Gatwick Airport Northern Runway Project

Statement of Common Ground Between Gatwick Airport Limited and Crawley Borough Council – Tracked Version

Application Document Ref: 10.1.1

Temporary Sussex Border Path Diversion

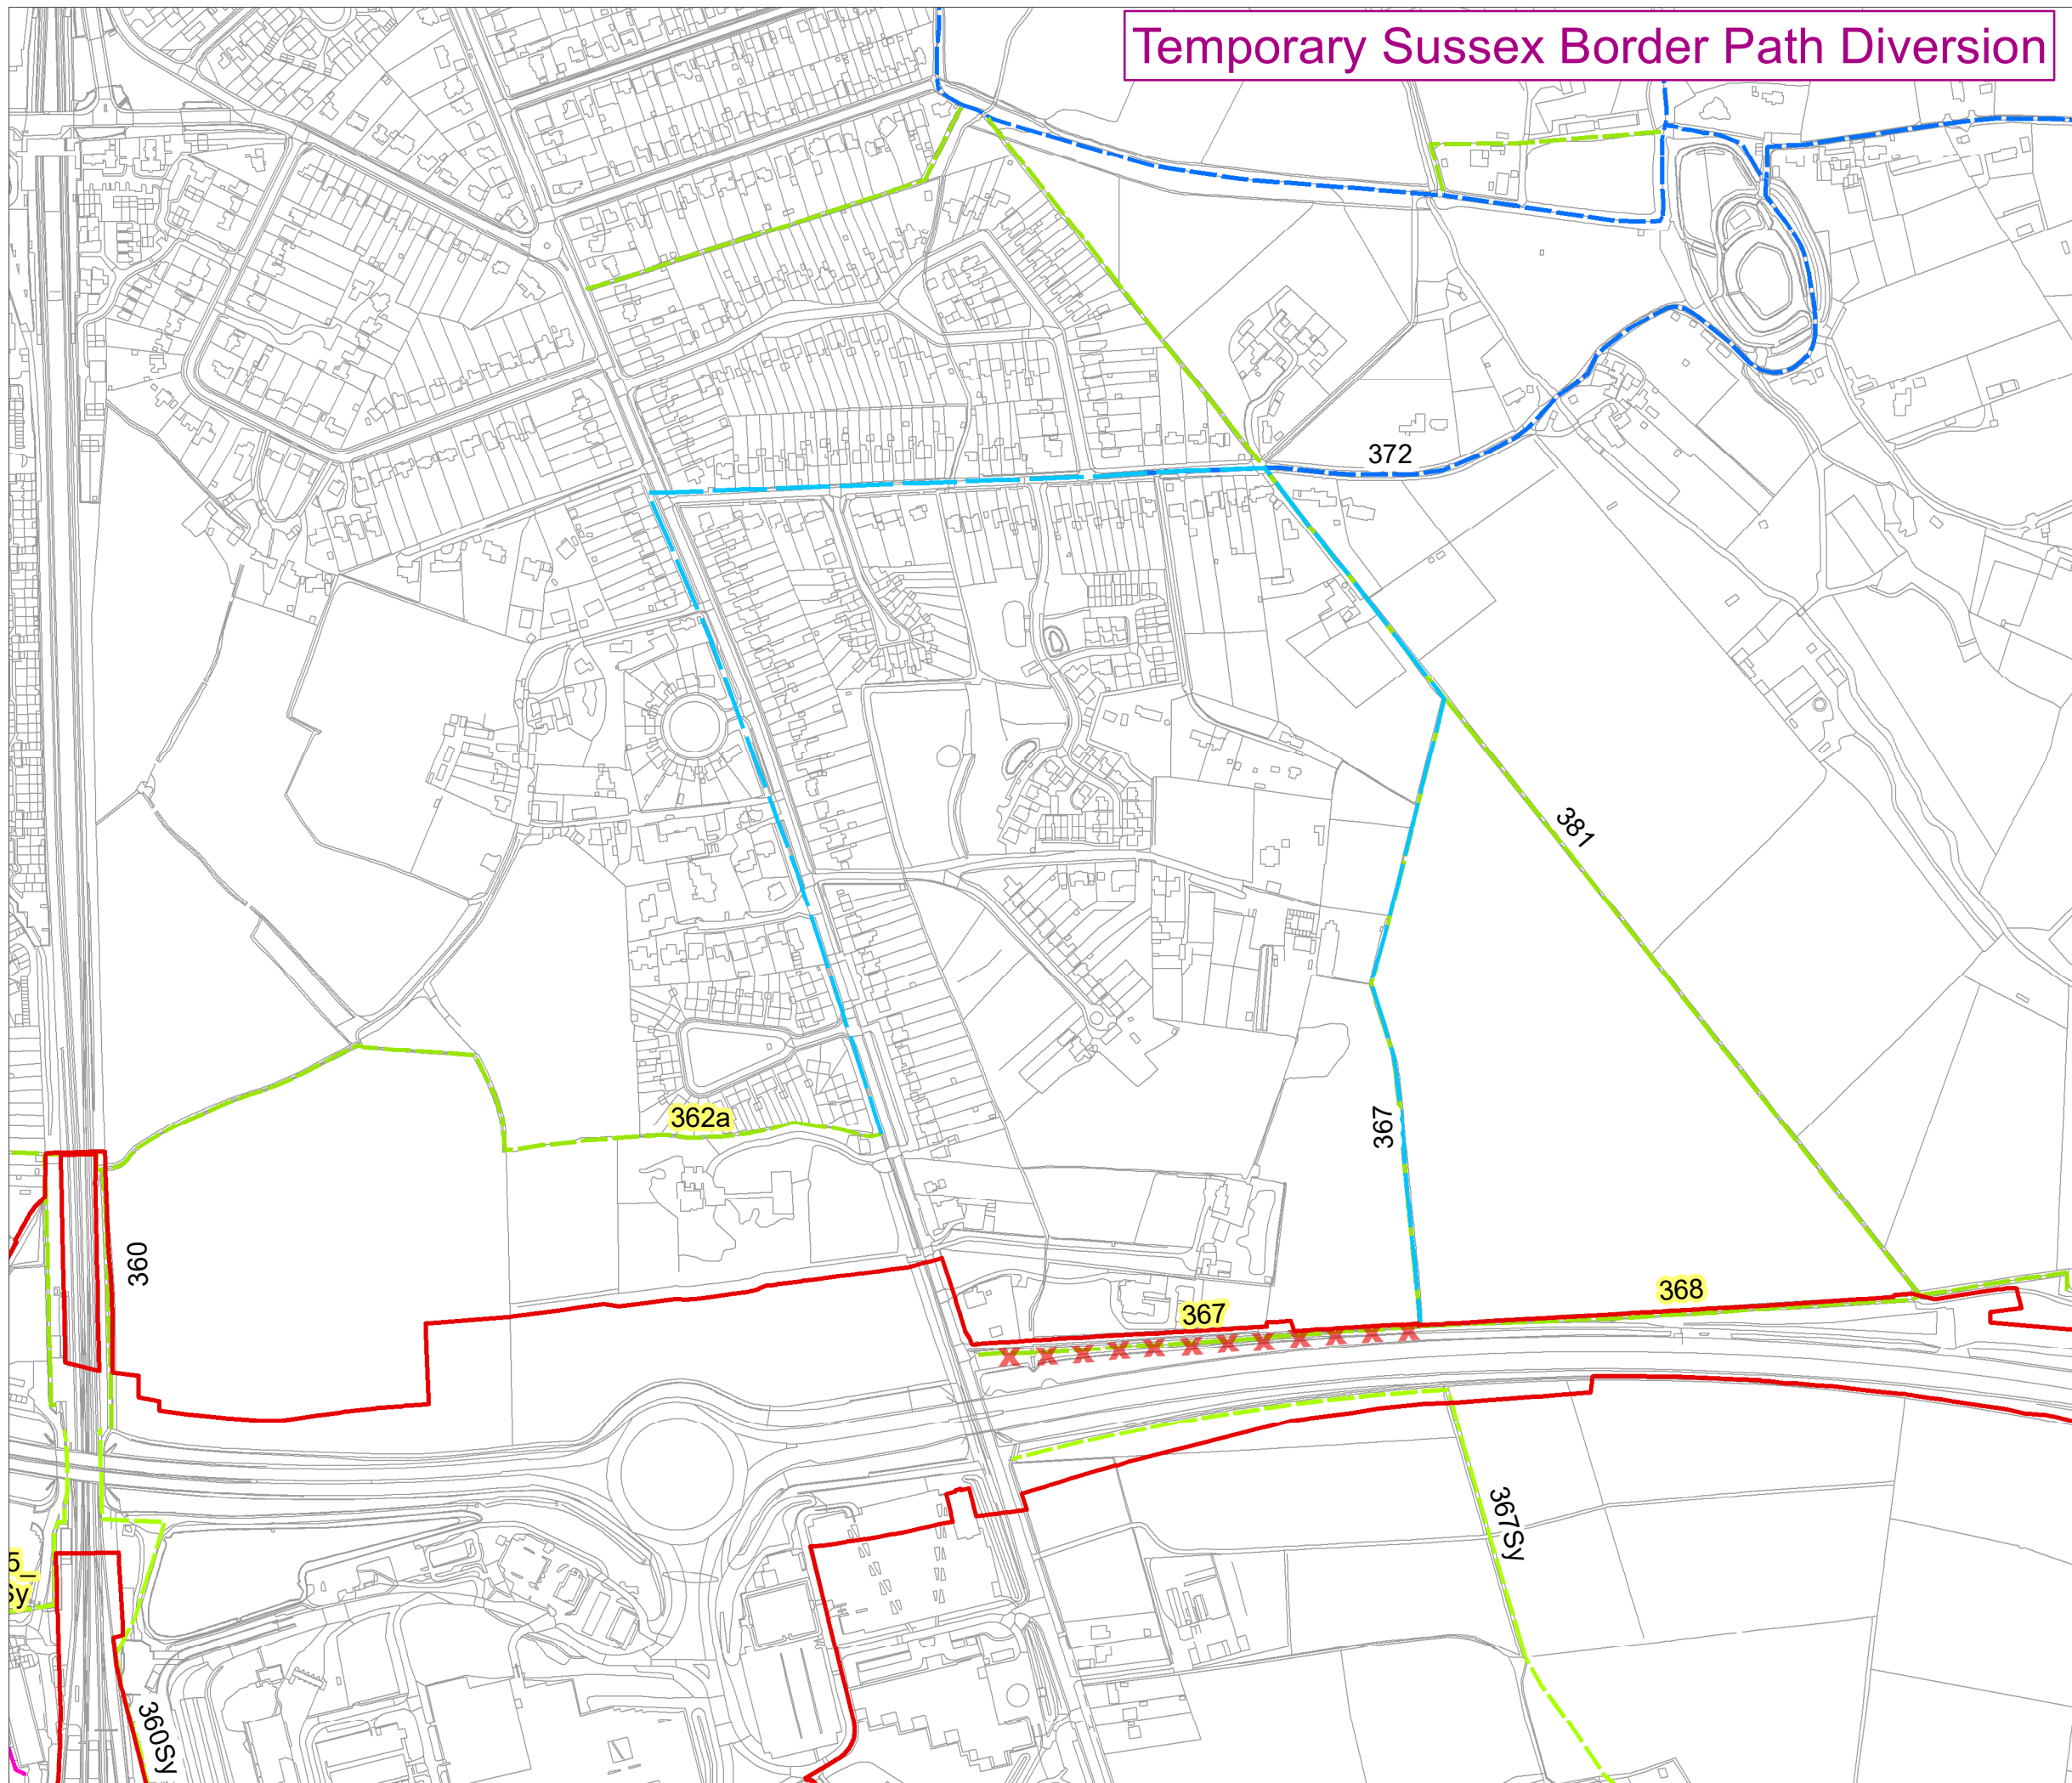
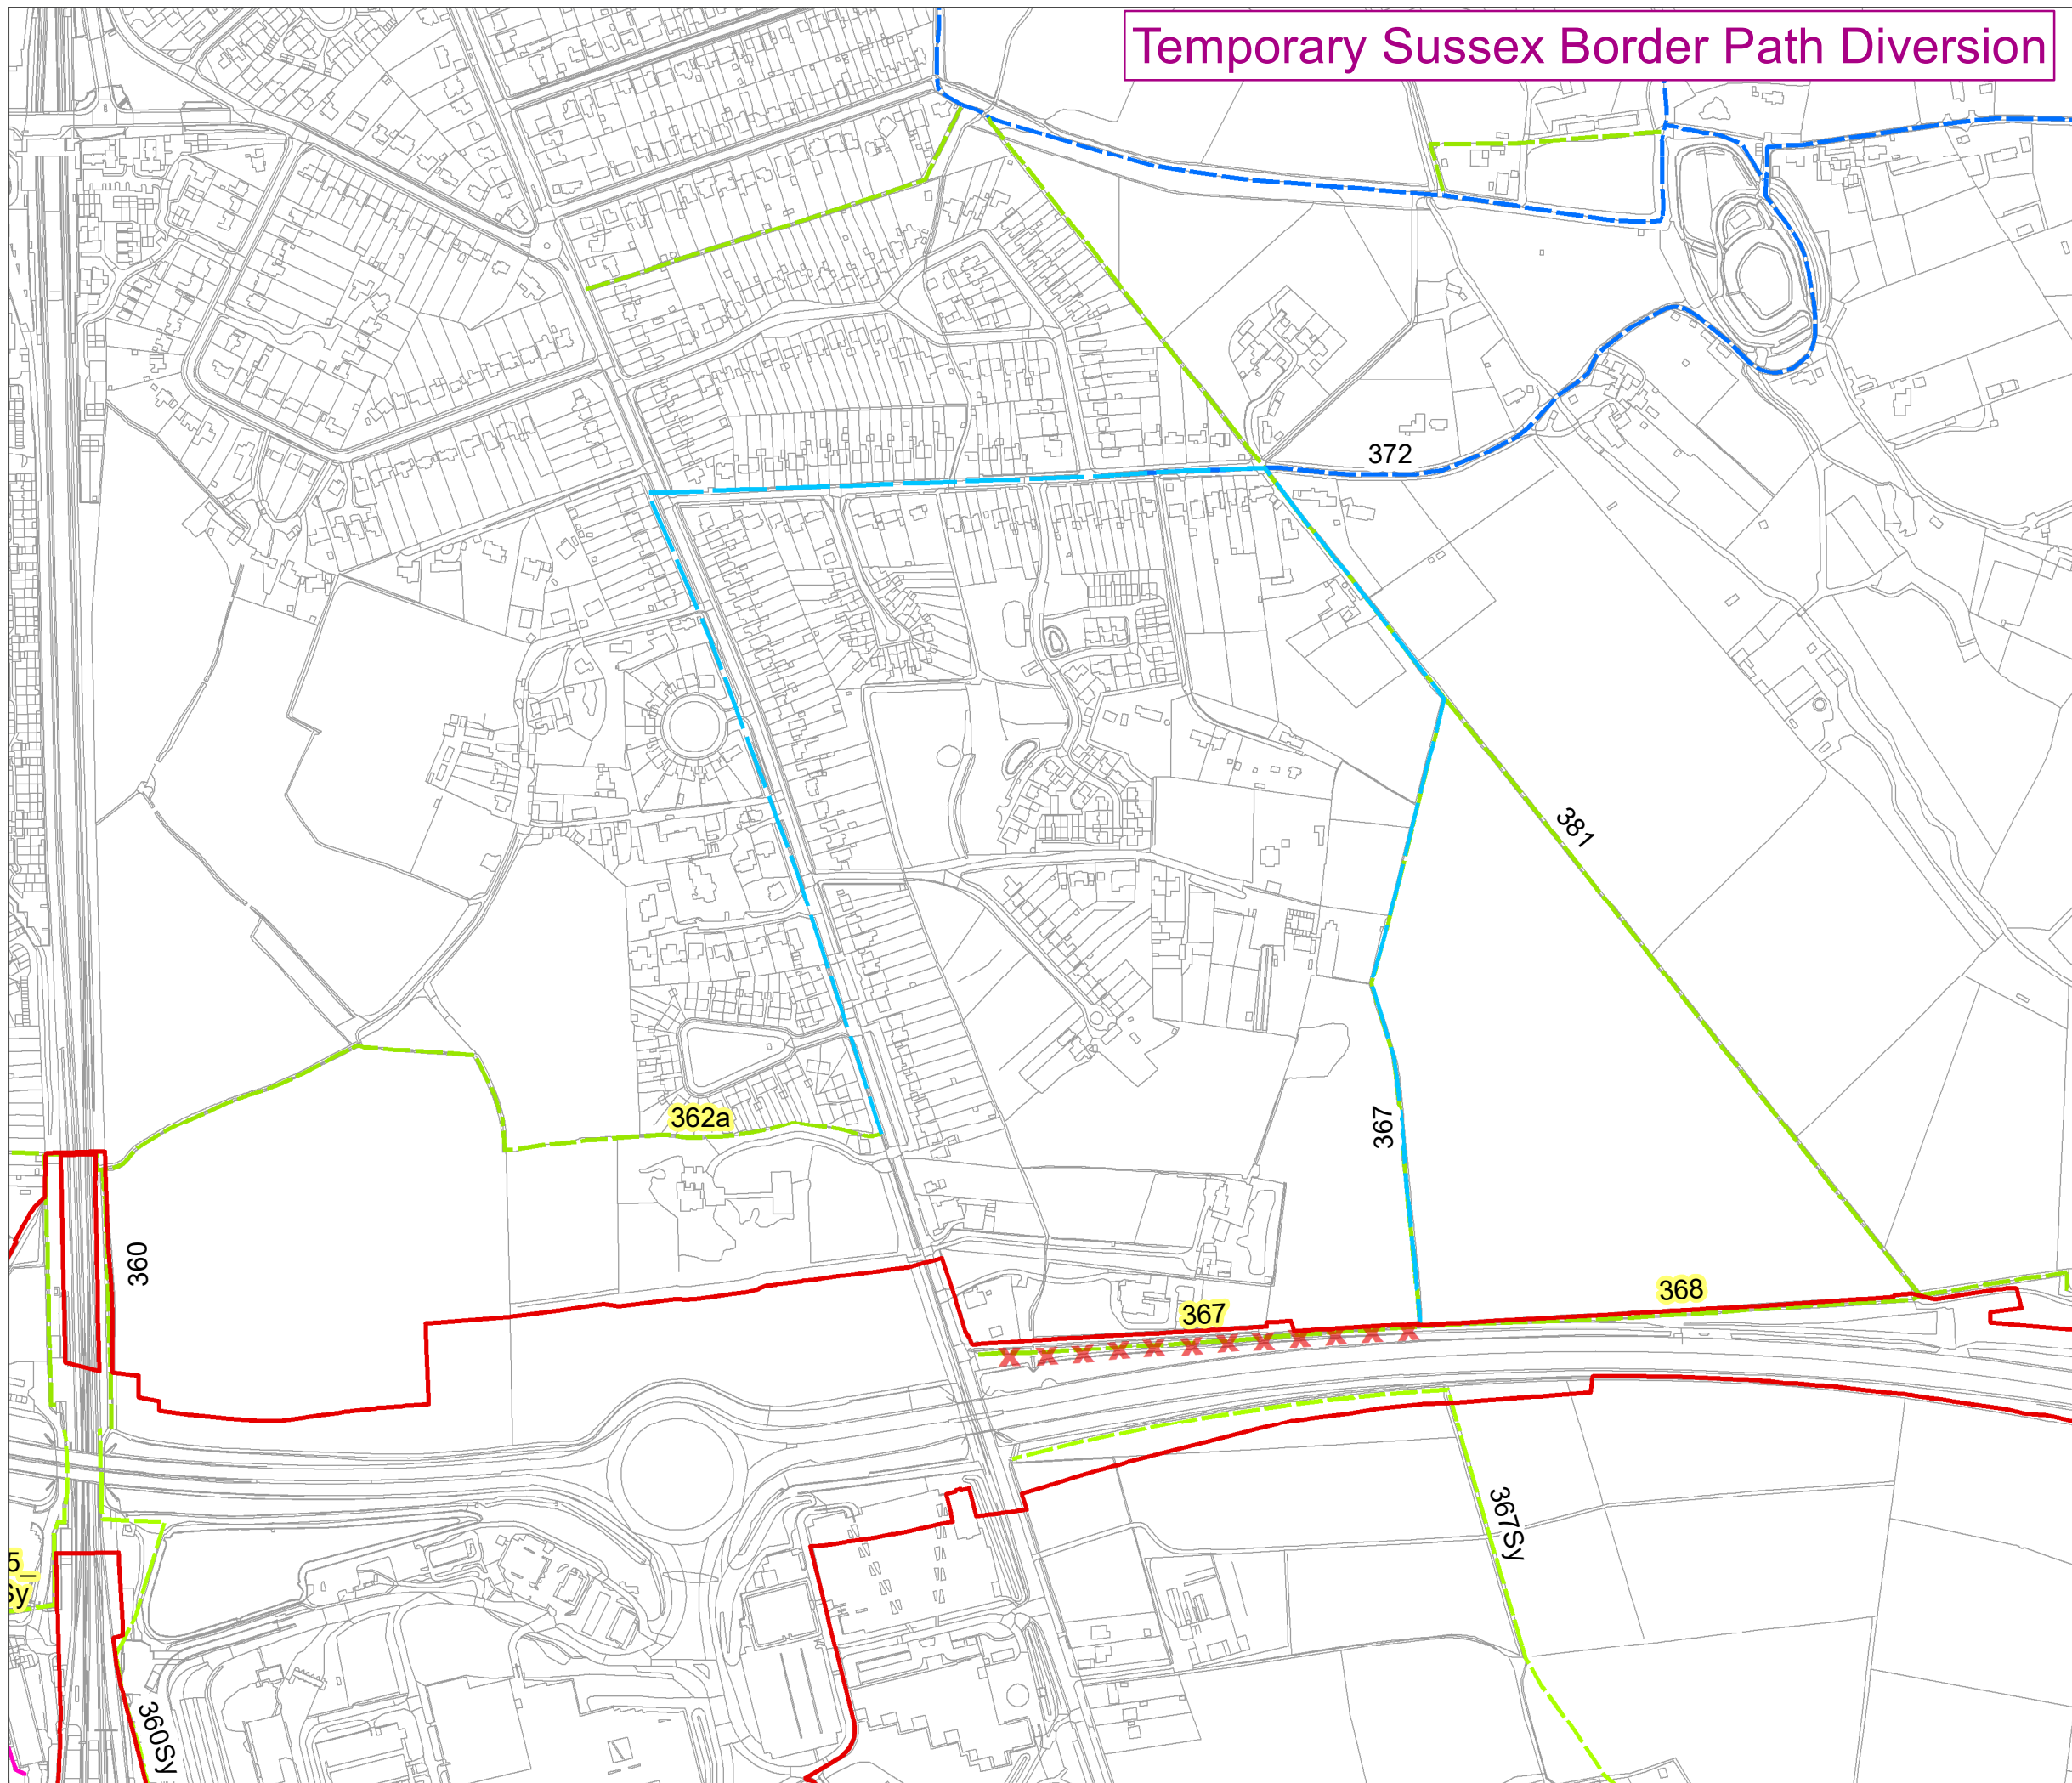
<p>set out most recently in paragraph 2.80 of the West Sussex Authorities comments to submissions made at Deadline 3 [REP4-042]</p>	<p>layout is shown in the ES Appendix 5.2.1: Surface Access General Arrangement Plans.</p> <p>In respect of the Sussex Border Path, the proposed temporary diversions of PROW routes during construction have been developed to maintain safety for PROW users during construction. Additional details in relation to the management of temporary PROW diversions is set out in Section 4 of the Environmental Statement Appendix 19.8.1: Public Rights of Way Management Strategy. Further details in relation to the temporary diversion provisions will be developed in consultation with the local authorities through the construction stage post-DCO consent.</p> <p>A PROW management strategy document, secured as a Requirement in the Draft DCO has been produced as part of the ES at Appendix 19.8.1 Public Rights of Way Management Strategy. The strategy describes the approach to managing the impacts on PROW because of the construction and operation of the Project to reduce disruption to users (as far as possible).</p> <p><u>Updated Position (April 2024):</u></p> <p>In relation to the provision of Active Travel as part of the Project.</p> <p>Appendix A to the Deadline 1 Submission - The Applicant's Response to Actions from Issue Specific Hearing 4: Surface Transport [REP1- 065] provides details of the active travel provision provided as part of the Project.</p> <p>In relation to the management of PROW during construction:</p> <p>The ES Appendix 19.8.1: Public Rights of Way Management Strategy [REP2-009] at paragraph 1.1.3 states that "Detailed PROW implementation plans would be in general alignment with the PROW Management Strategy for the Project and subject to approval by the relevant Local Planning Authority (LPA)". This is secured by DCO Requirement 22. The Strategy identifies the definitive PROW likely to be affected by the Project, including Footpath 359-sy and 360-sy, where PROW implementation plans would be likely to be required. Pentagon Field is proposed to be used for the deposition of spoil from excavations within the Project and will then be restored to grassland which can be returned to its former agricultural use. During the works to deposit spoil, management measures may be required, in accordance with the principles in the PROW strategy, to ensure that</p>	<p>Surface Access Highways Plans – General Arrangements [APP-020]</p> <p>The Applicant's Response to Actions from Issue Specific Hearing 4: Surface Transport [REP1- 065]</p>

<p>access to Footpath 359sy remains throughout the construction period.</p> <p>Footpath 360sy would be subject to a PRow implementation plan during the construction of the project as identified in Table 4.4.1 or the PRow Strategy, where a temporary stopping up and diversion of this route would be required in association with the construction of the highway works to accommodate the widening of the railway bridge for the additional third lane for Airport Way westbound. Whilst considered unlikely, if an additional management measure (a managed crossing) is required in relation to the management of this footpath during works to construct the pumping station to the east of the railway, these can be accommodated as part of the implementation plan for this footpath that would be agreed with the LPA.</p>
